Application No: FP/148/25/HH  
Site Address: 2 Ormesby Crescent Felpham PO22 8EN  
Description of works: Pitch roof to the existing detached garage, new pitch roof porch and pitch roof dormer together with bow windows to existing windows to the front elevation and a flat roof dormer to rear elevation forming new bedroom suite and bathroom.

Thank you for your internet representation made on 5th November 2025 which has been recorded as no objection with the comments as follows:

Title
Plans as Proposed

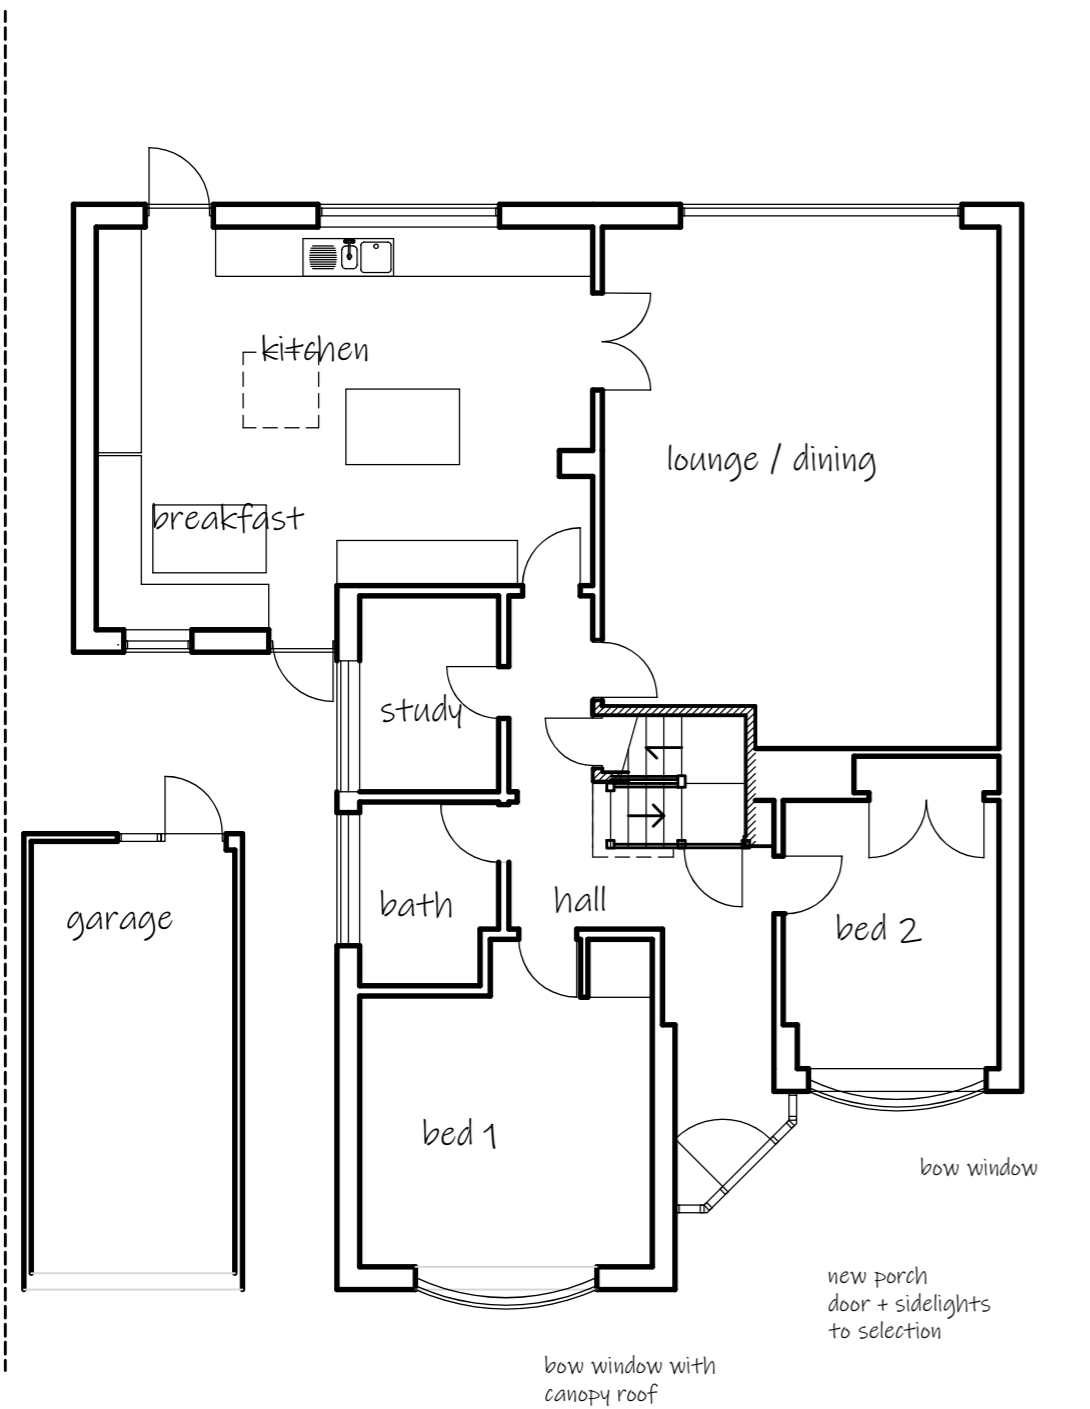
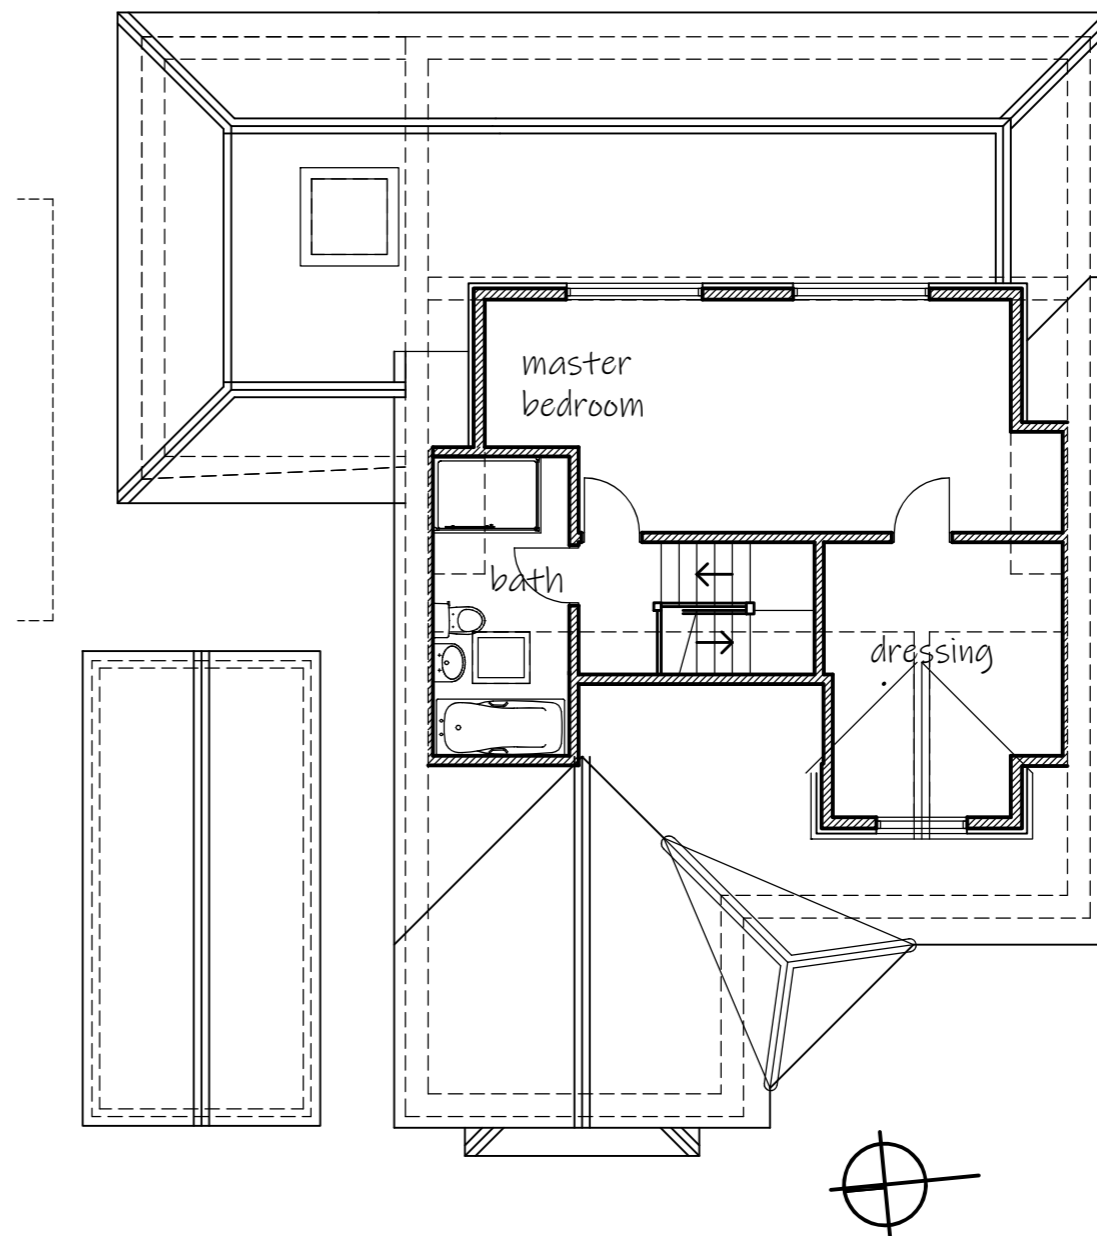
Note: No dimensions or distances from boundaries shown on plans. Concerns regarding the potential sight lines affecting neighbouring properties.
